WEST SUSSEX COUNTY COUNCIL CONSULTATION

TO:	Arun District Council FAO: Michael Eastham
FROM:	Stephen Gee WSCC - Highways Authority
DATE:	22 July 2021
LOCATION:	Land East of Tye Lane Walberton BN18 0LU
SUBJECT:	WA/63/21/PL Proposed alternative vehicular accesses off Tye Lane and emergency access off Avisford Park Road, along with minor highway works following WA/95/18/RES (resubmission following WA/93/20/PL). This site is CIL Zone 2 (Zero Rated) as other development.
DATE OF SITE VISIT:	n/a
RECOMMENDATION:	Advice / More Information
S106 CONTRIBUTION TOTAL:	n/a

VIEWPORT 1 - PROPOSED RESIDENTIAL ACCESS AT TYE LANE

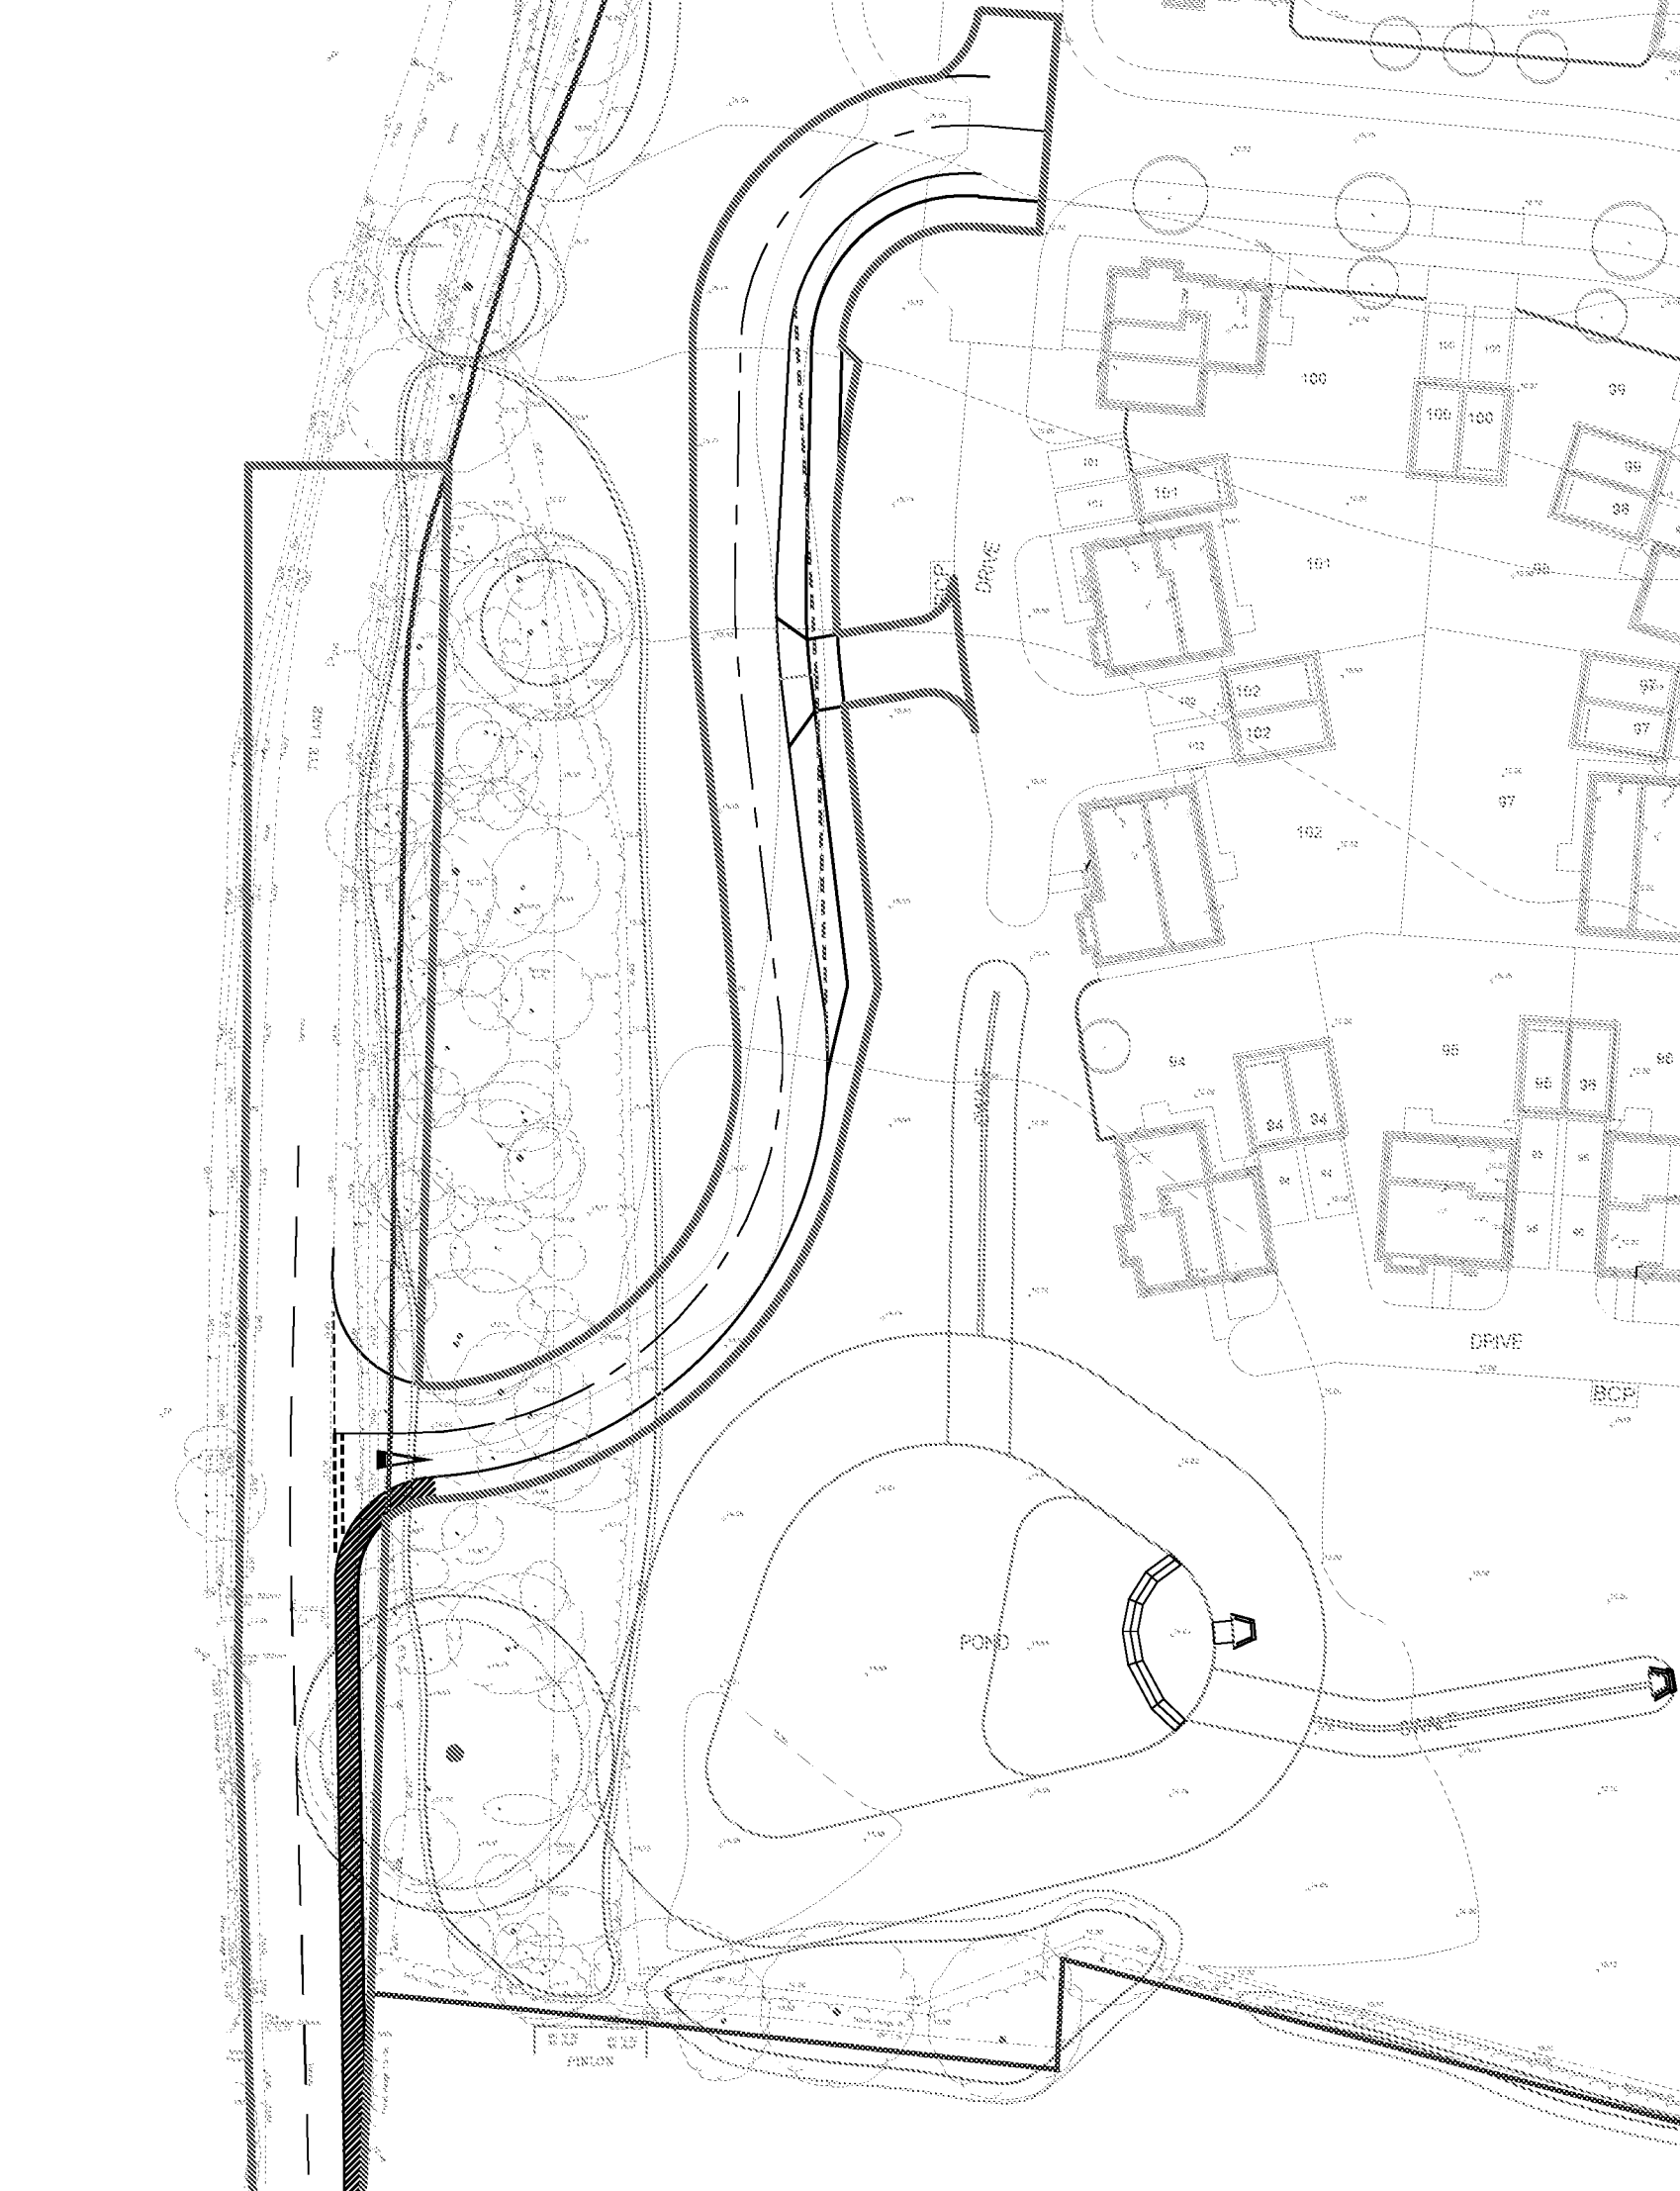
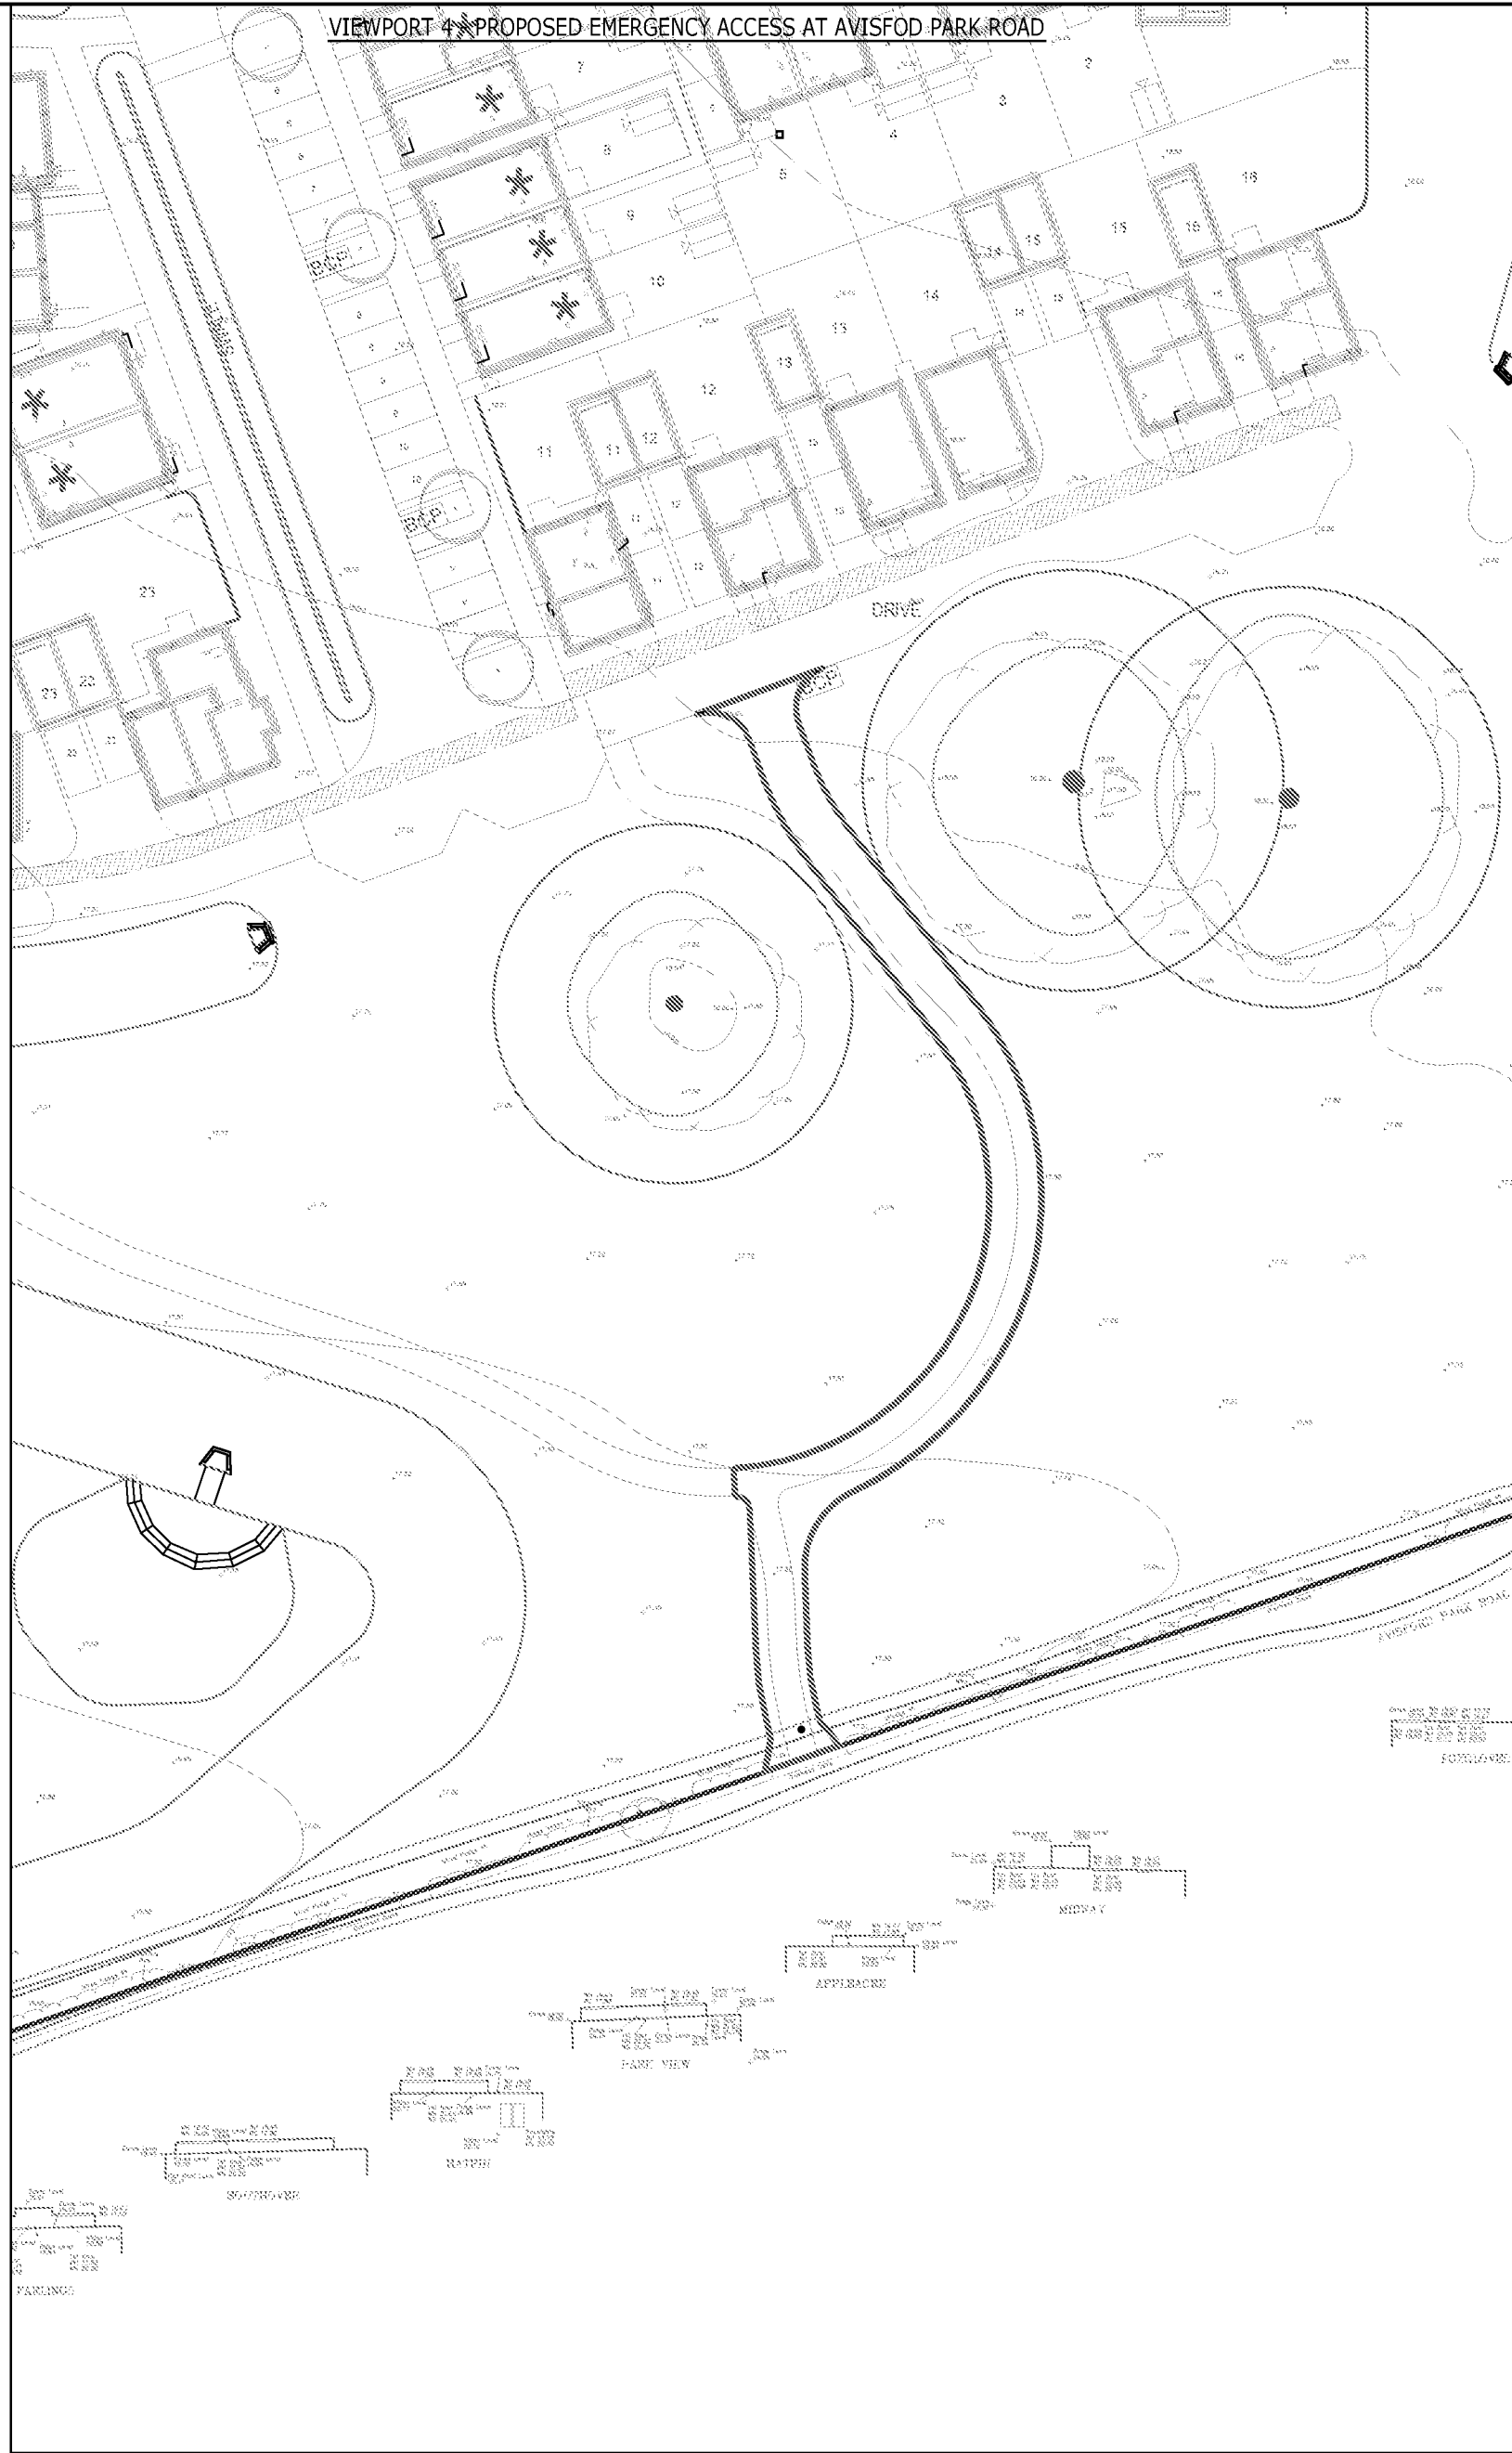
A simple priority junction is to be provided onto Tye Lane as shown on Drawing number 183248-002/003 with a 5.5m wide carriageway and 7m kerb radii. Visibility splays of 2.4m x 54m southbound and 2.4m x 60m northbound are achievable in line with Manual for Streets requirements.

A new 1.5m footway is proposed along the eastern side of Tye Lane where there is currently none. The footway reduces to 1.2m for approximately 25m. Given the anticipated vehicle

flows, alternative pedestrian accesses to the site and land constraints the width proposed is acceptable.

In order to accommodate the footway the carriageway width is to be narrowed to between 5.6m and 5.0m. A 5m (over 4.8m) road width would allow a HGV and car to pass.

Vehicle tracking has been provided for the emergency access which shows a Fire Tender can utilise the access and internal links within the development. (Although noting it is highly unlikely a fire tender would ever approach western end of Avisford Park Road). A removable bollard would be provided to allow ped / cycle movements as within the existing approved application and restrict public motor vehicles.
